# CITY OF ALBUQUERQUE

10-23-23

**Re: Roses Southwest Papers**  
**No address- UPC 101605227405540202**  
**Traffic Circulation Layout**  
Engineer's/Architect's Stamp 10-17-23 (Q16-DA5000C)

A1
TRAFFIC CIRCULATION LAYOUT
- PHASE 1
SCALE: 1" = 40'-0"

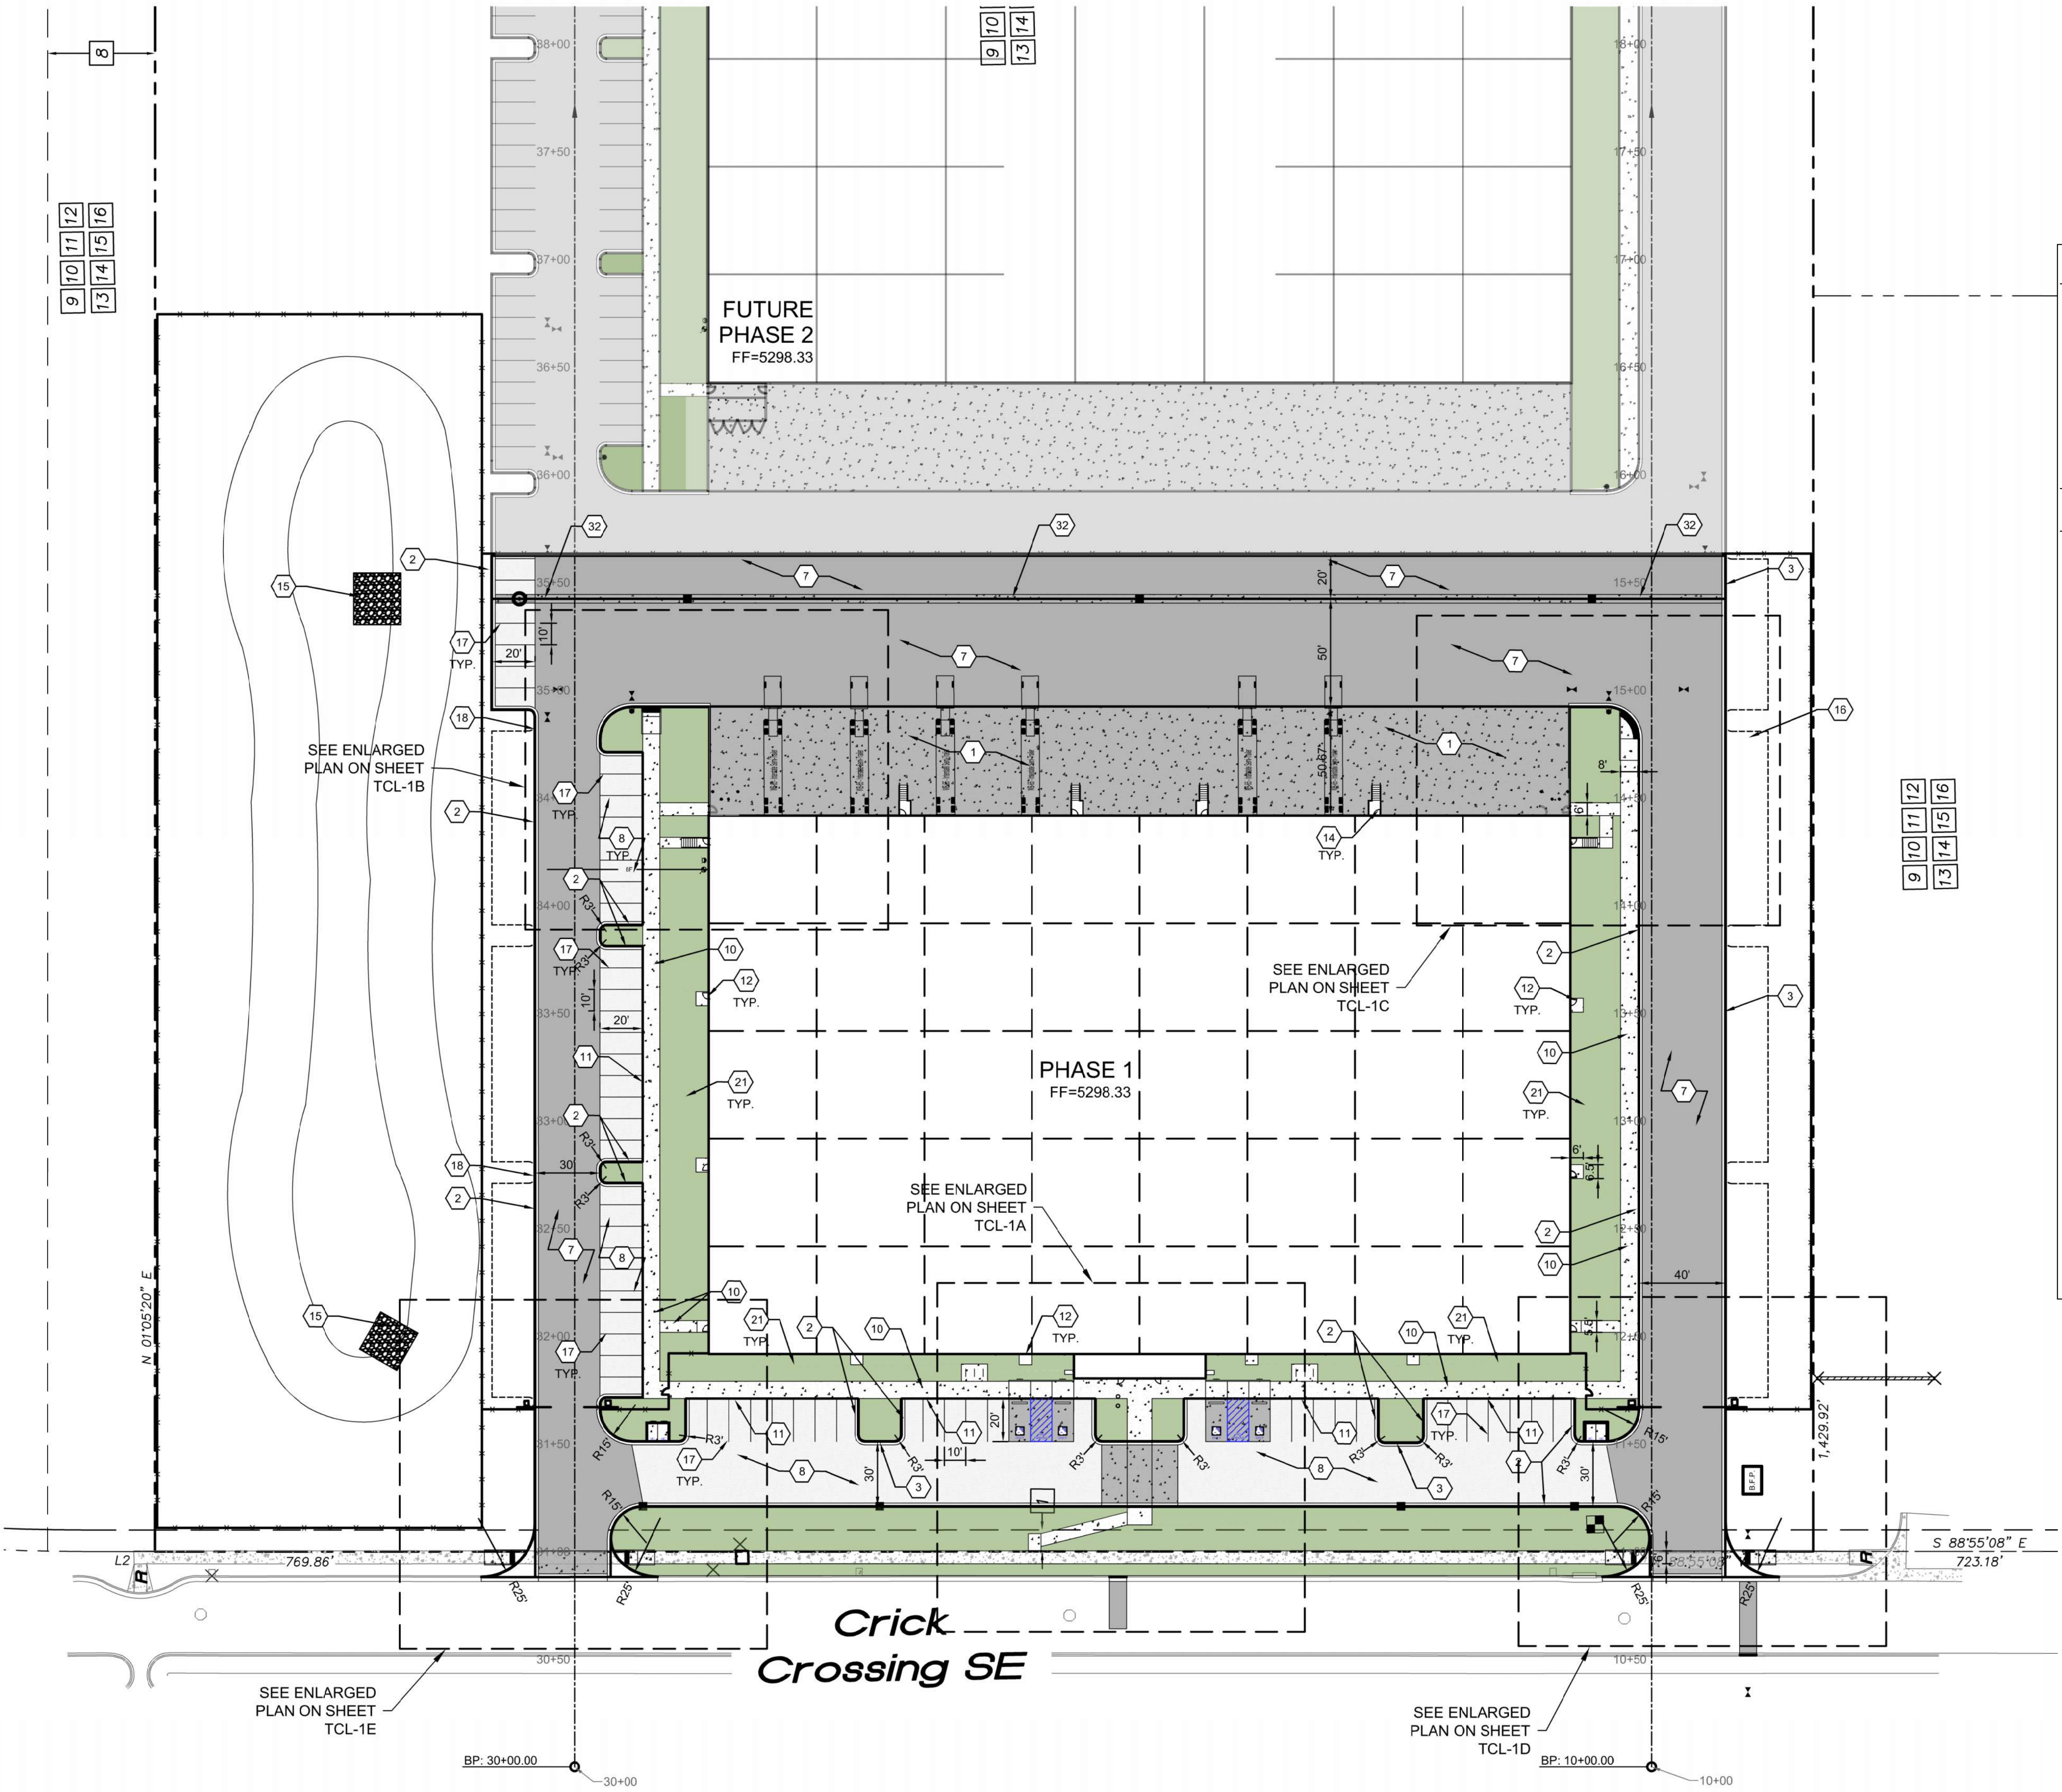
1. Please redo the parking count table. The total of 52 is Ok with 50 coming from the Wholesale and Storage and 2 coming from the office use. However, once the total number of spaces is determined, then the number of MC, ADA and bicycle spaces is based on the total number of parking spaces not per use as shown. In addition:

- a. Change MC required to 3
  - b. Change HC required to Total 4 Van 1
  - c. Change Bike required to 5
2. I counted 66 spaces not 67.
3. Along the sidewalk keyed Note 10, there should be a curb or parking bumper to prevent vehicles from overhanging more than 2 ft.

4. Provide at least one van Accessible parking space.
5. Specify the sidewalk width.
6. Show the ada accessible path from the ROW to the building
7. Submit sheets 501, 502 for review.

8. Access from the HC parking spaces is to be to the directly to the sidewalk to the north, with a ramp(s).
9. The east entrance is wider than the maximum allowed (30') per the DPM and the radius is smaller than specified for a WB-65. Please change the site access to 30' wide with radii of 35' for the west radius. OK to keep the east radius at 25'. This may require shifting the entrance east to miss the inlet in Crick Ave.

10. Send Fire and Solid Waste Dept. approvals.
11. Where is the refuse container?
